Recommendation Report for Planning Permission for Works or Extension to a Dwelling

REF NO: EP/51/26/HH

LOCATION: Dene Cottage
156 Sea Road
East Preston
BN16 1PB

PROPOSAL: Proposed single storey front extension / porch and new pitched roof over existing garage.

Drawing Number: AR-204-03

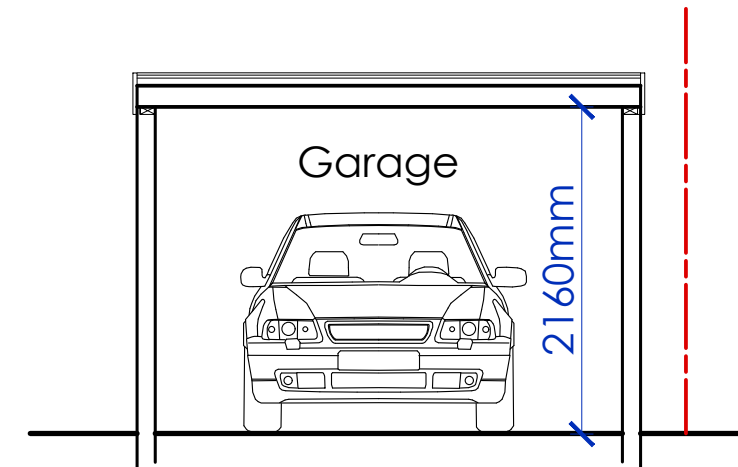
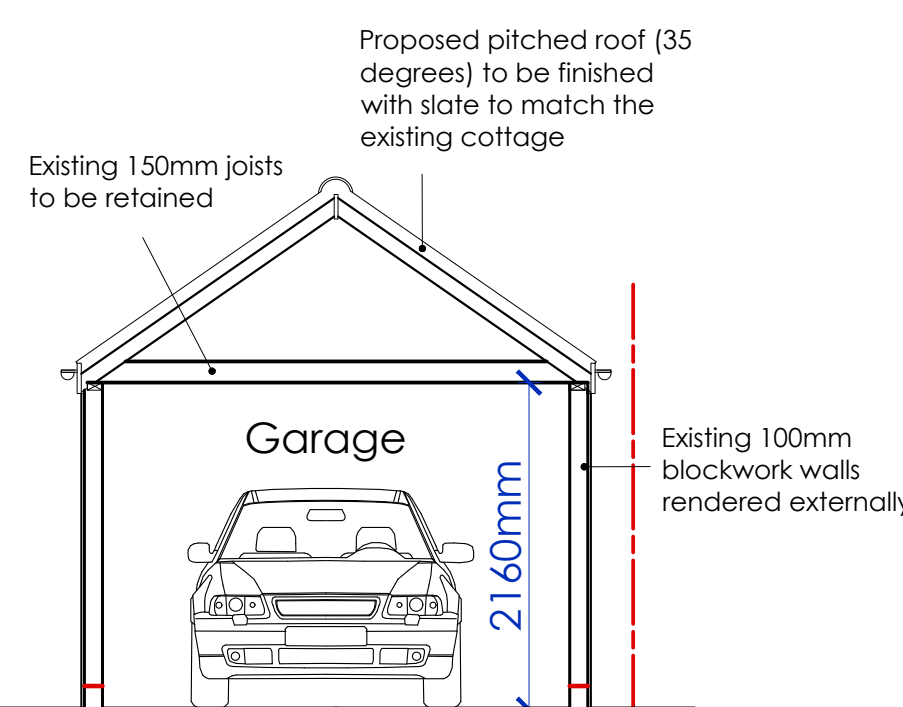
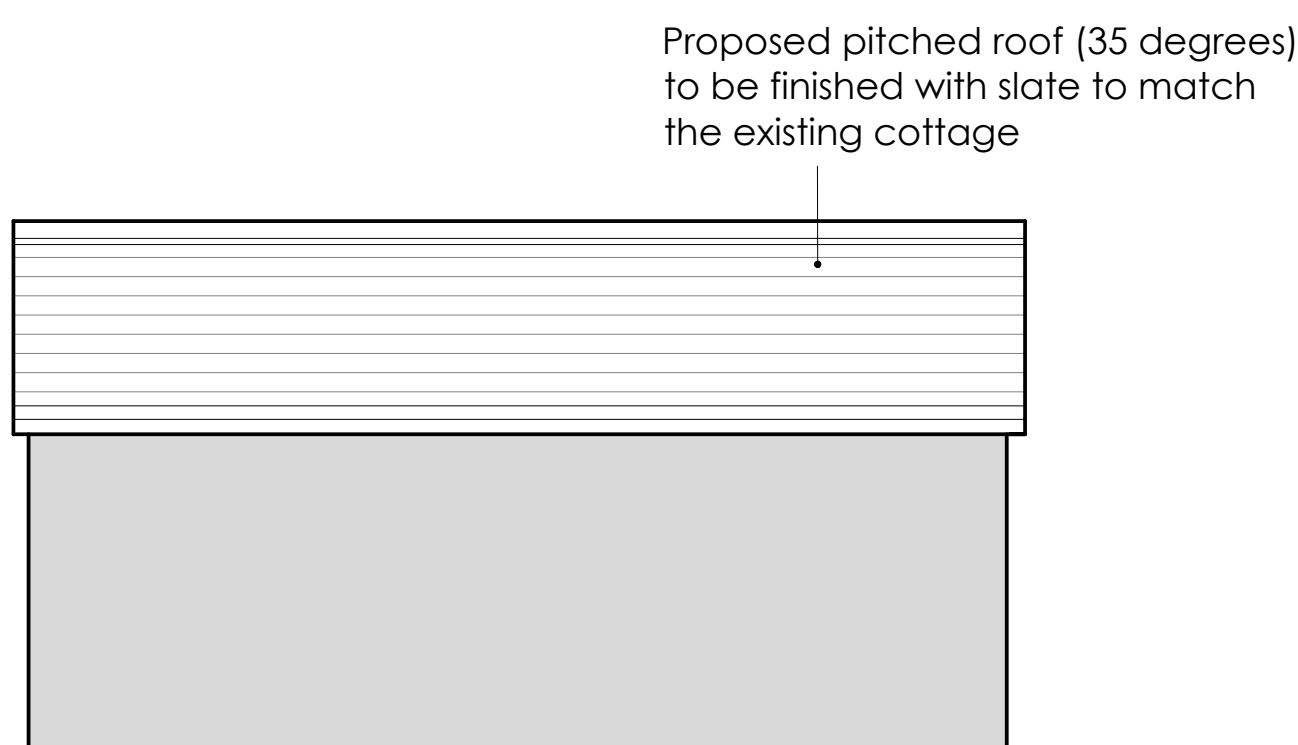
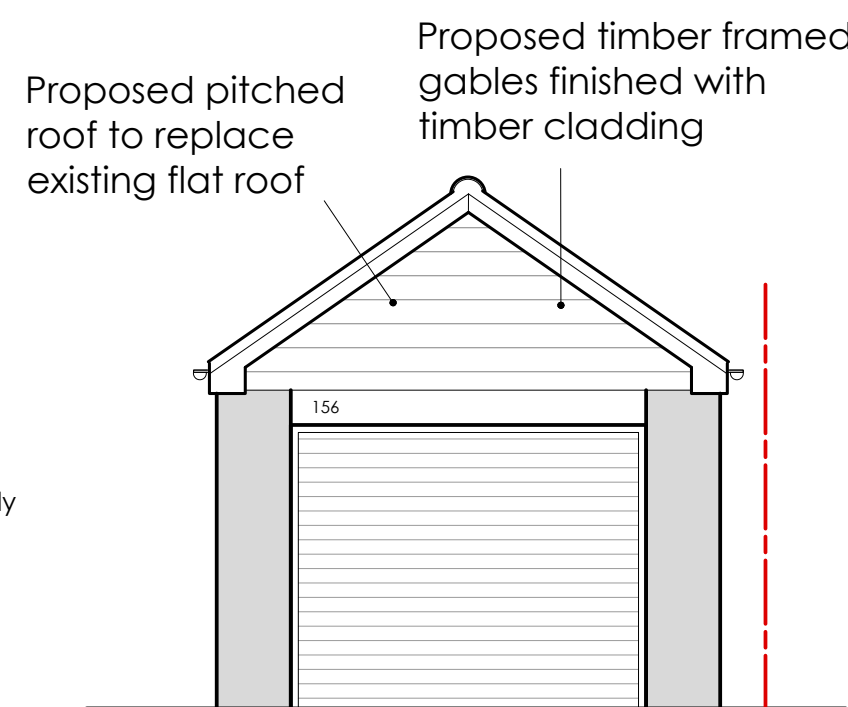
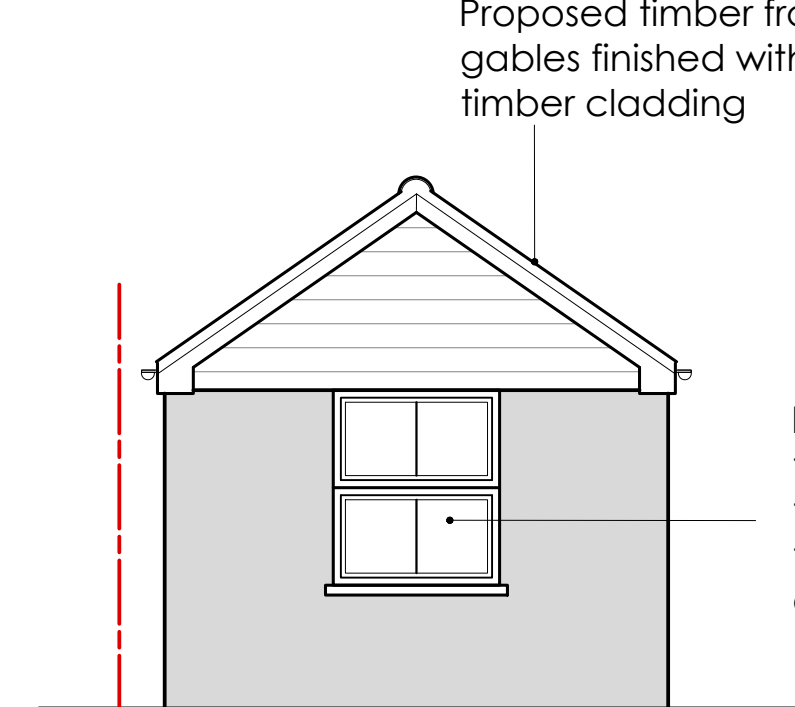
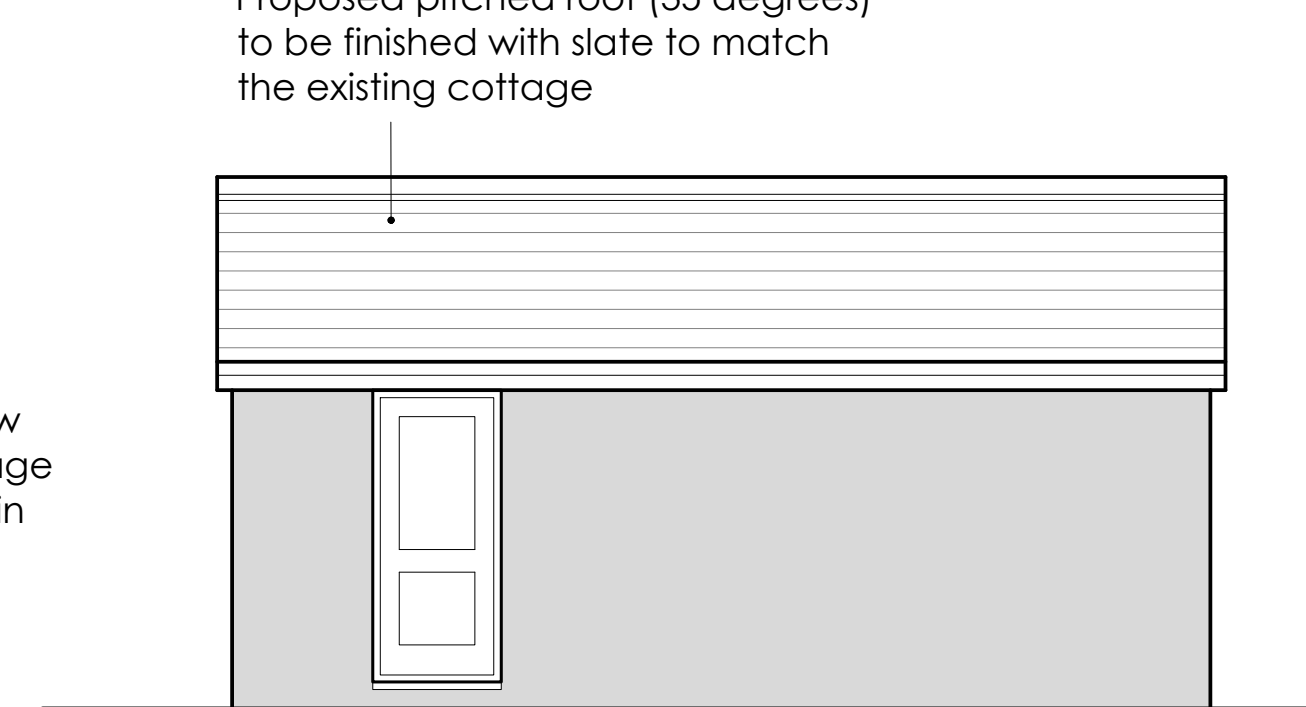
It is proposed to replace the existing flat roof of the garage with a pitched roof, with a ridge height of 3.4m, 1m taller than the flat roof. Despite the increase in height, the pitched roof would be a more subservient, appropriate design choice, reflecting the roof form of the host dwelling, with matching slate tiles, contributing towards a pleasing sense of continuity throughout the site. The gables of the extension would be finished with timber cladding.

Further to this, the materials proposed as part of the application would be a pleasing continuation of the established character; in the case of the garage, amendments to the finishes, materials and roof form would enhance the AOC.
